Charlotte Storm Water
600 East Fourth Street
Charlotte, N C 28202-2844

Rezoning Petition Review

Date of Review: March 23, 2020 (**Revised April 16, 2020**)

Rezoning Petition #: 20-19

**RZ-1**

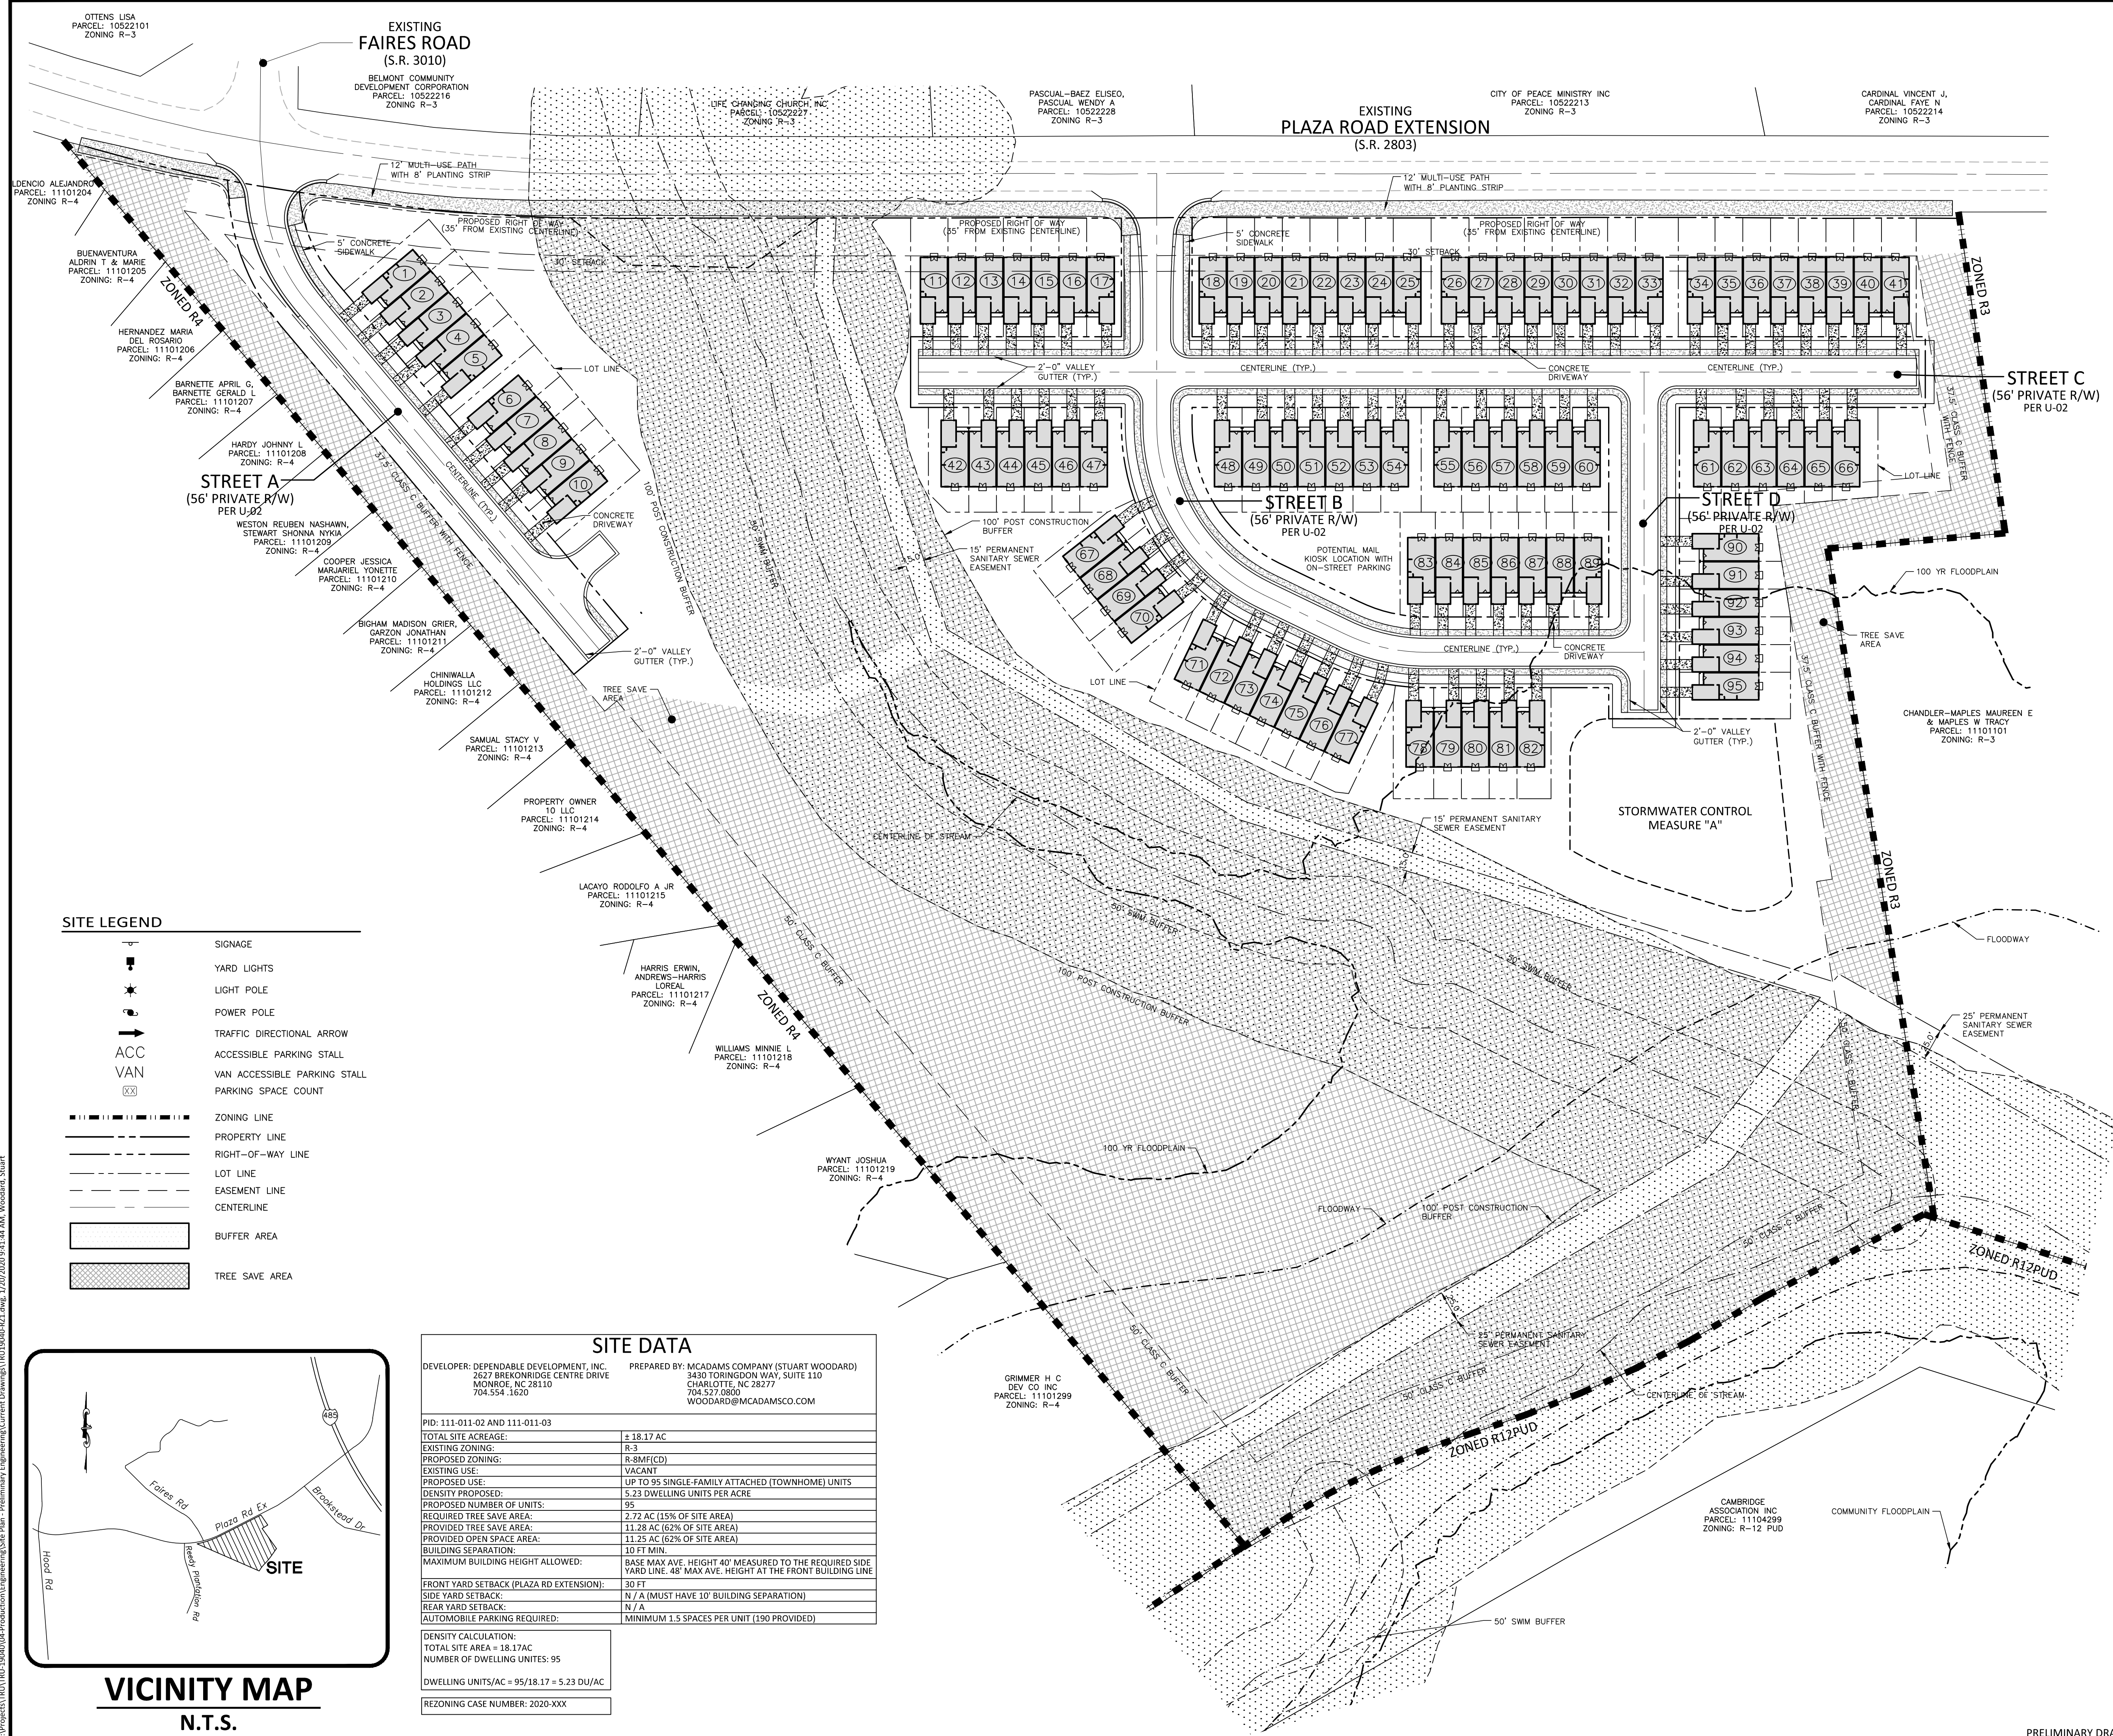
Concerning Storm Water: The proposed rezoning plan sheet indicates a proposed location for storm water management. Please include the following notes on the plan sheet under "Environmental Features": *The location, size, and type of storm water management systems depicted on the Rezoning Plan are subject to review and approval as part of the full development plan submittal and are not implicitly approved with this rezoning. Adjustments may be necessary in order to accommodate actual storm water treatment requirements and natural site discharge points.*

Please update *100' Post Construction Buffer* to read *100' Undisturbed Post Construction Buffer*. Development within any SWIM/PCSO Buffer shall be coordinated with and subject to approval by Charlotte-Mecklenburg Storm Water Services and mitigated if required by City ordinance.
